PCU060886

30 July 2015

Modification Application to the State Significant Development at the M2 site within the North Ryde Station Urban Activation Precinct (SSD 5093 MOD 1)

RE: M2 site within North Ryde Station Urban Activation Precinct (SSD 5093)

FIGURE 12 – RELOCATION OF THE GAS MAIN

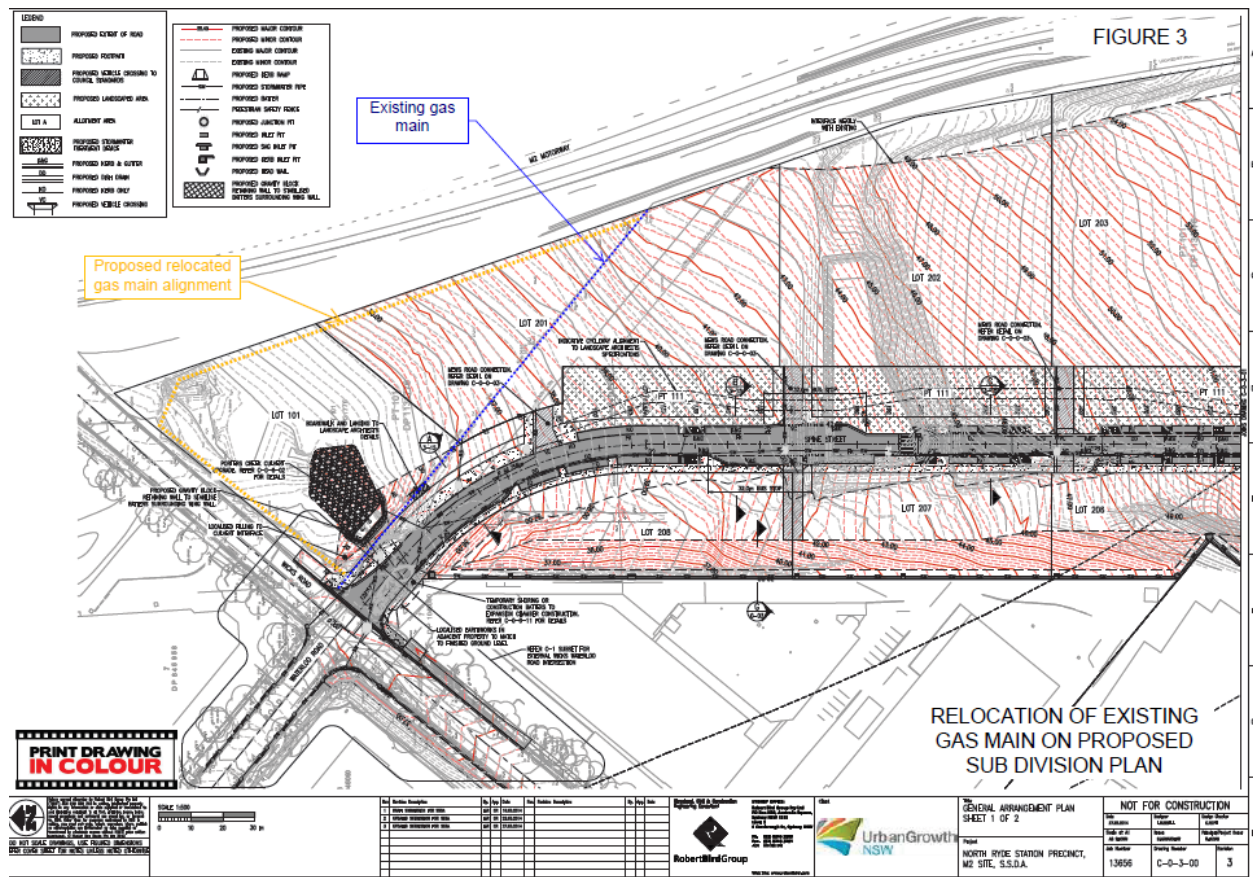
- The proponent is to ensure that the location of the relocated gas pipe does not adversely effect the operation of any Sydney Water assets.
- This is to be completed before construction work commences, and is a condition of obtaining a Section 73 Certificate from Sydney Water.
